17 January 2011

**Project Application for residential development (Buildings 1, 2 and 3)
at 61 Mobbs Lane, Epping (former Channel 7 site)**

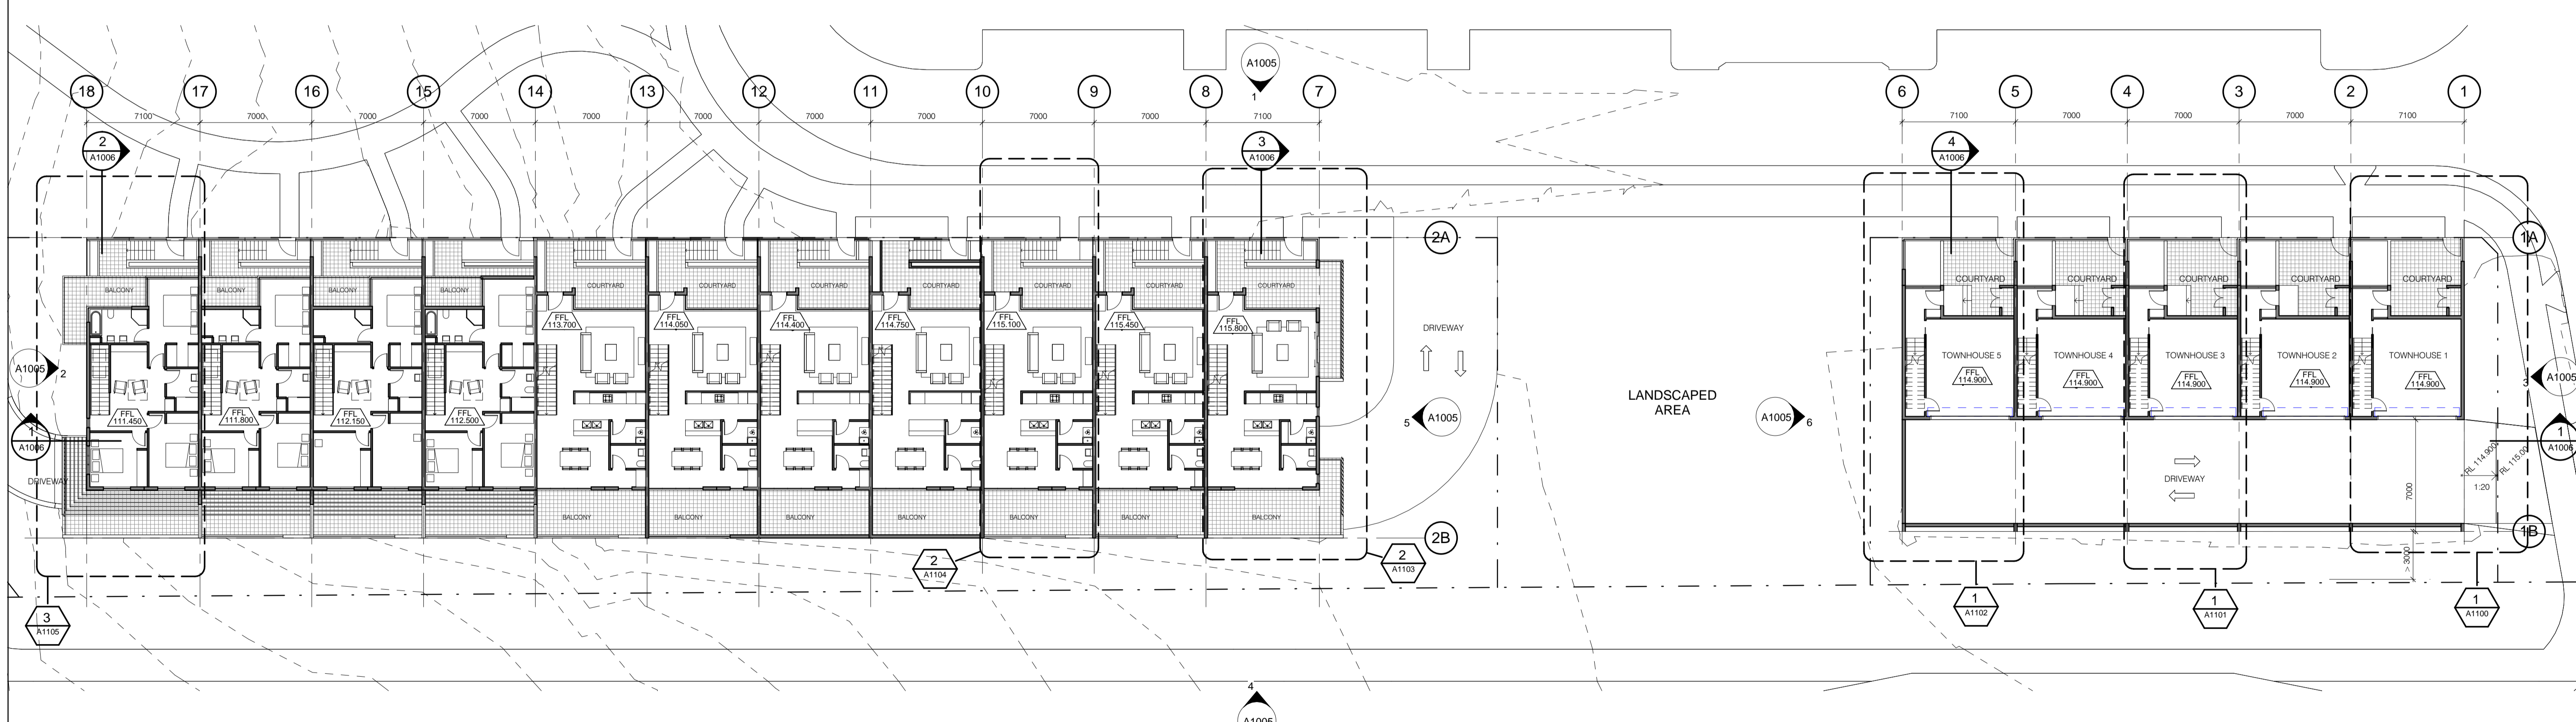
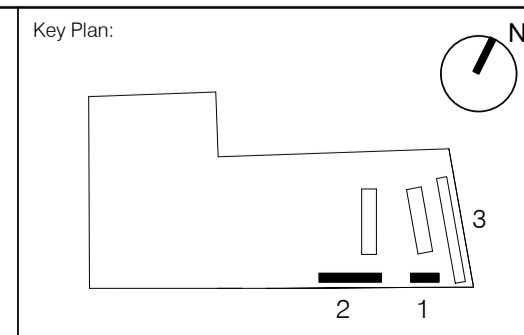
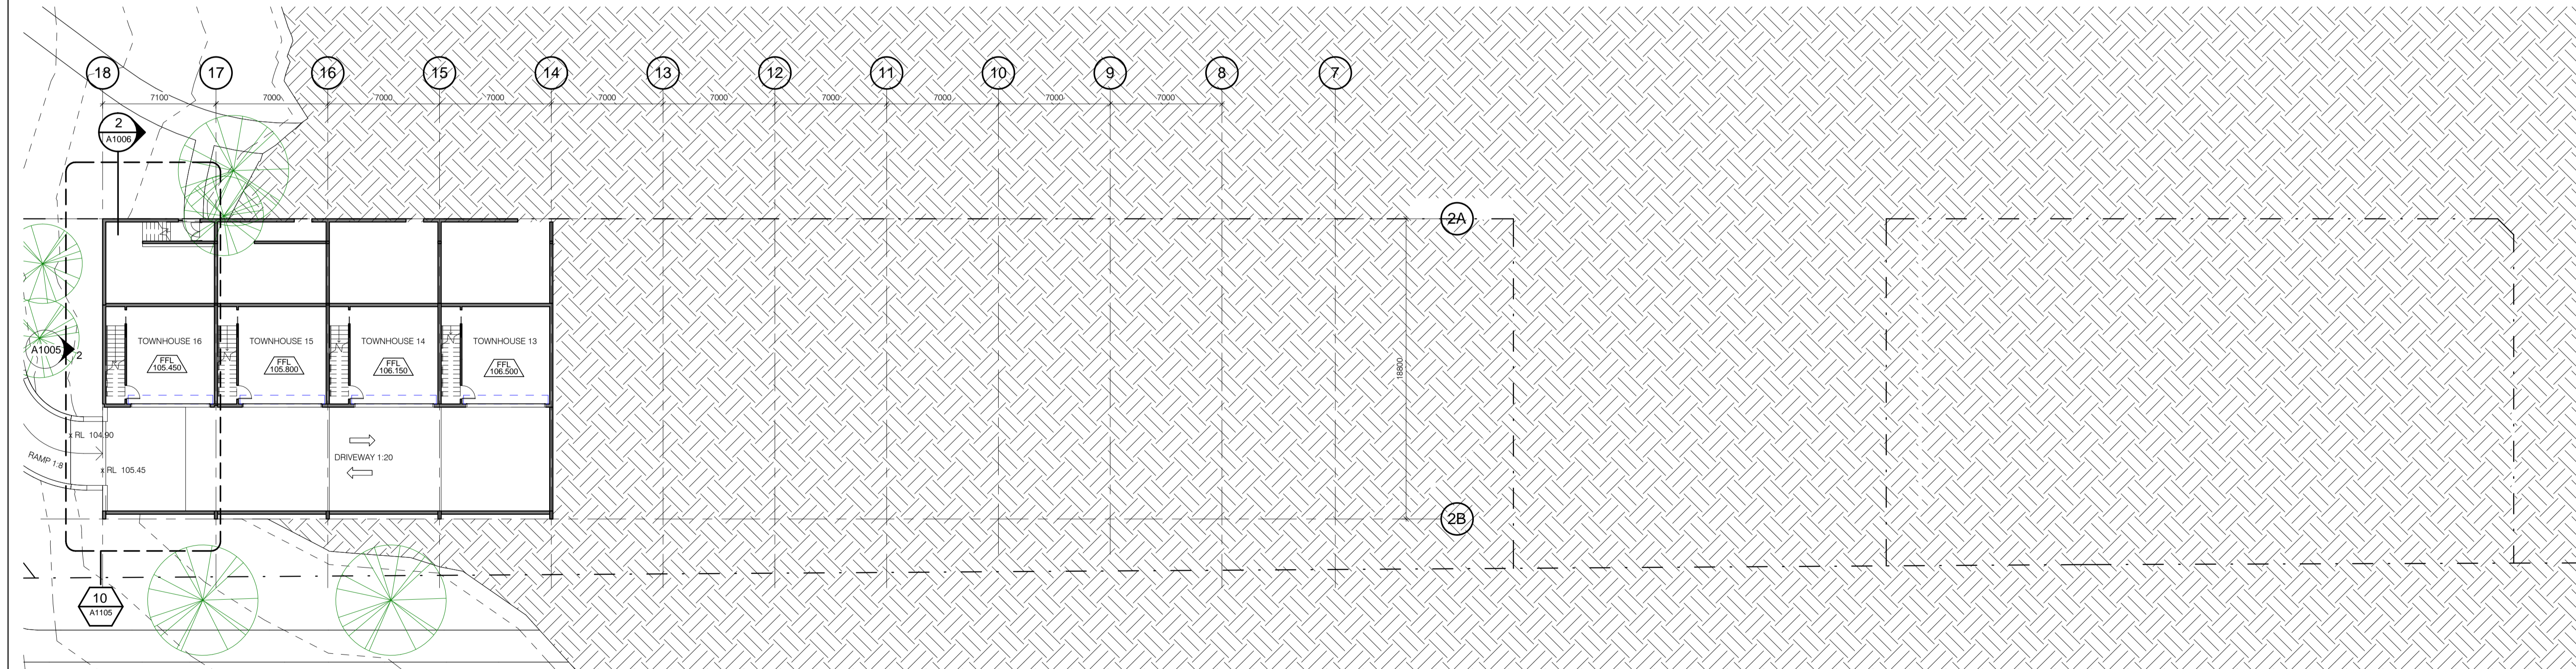
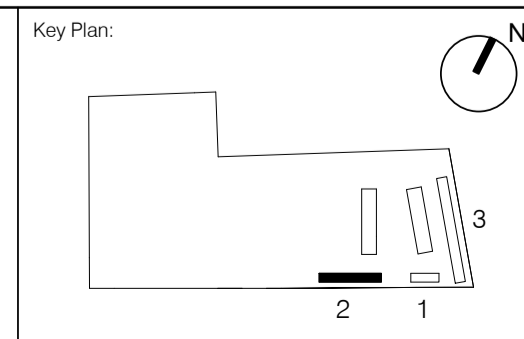
The Commission sought clarification on the derivation of the 56 off street car parking spaces for the residential dwellings and the requirement to permanently mark all off street parking spaces as recommended in the design modification outlined in condition B1(c).

At the briefing, the Department confirmed that the 56 off street parking spaces is based on Council's DCP requirement for 2 car spaces per dwelling. These parking spaces will be provided within the garages associated with each dwelling. It was noted each dwelling in Building 3 has the capacity for 2 additional car spaces (i.e. a total of 4 car spaces per dwelling) which would create a total of 80 off street parking spaces for the development.

The Department also confirmed that the permanent marking of off street parking spaces is a requirement of Council. After reviewing the conditions, the Commission did not consider it necessary to permanently mark off street parking spaces which will be provided in garages. As such, the Commission has deleted the design modification proposed in condition B1(c).
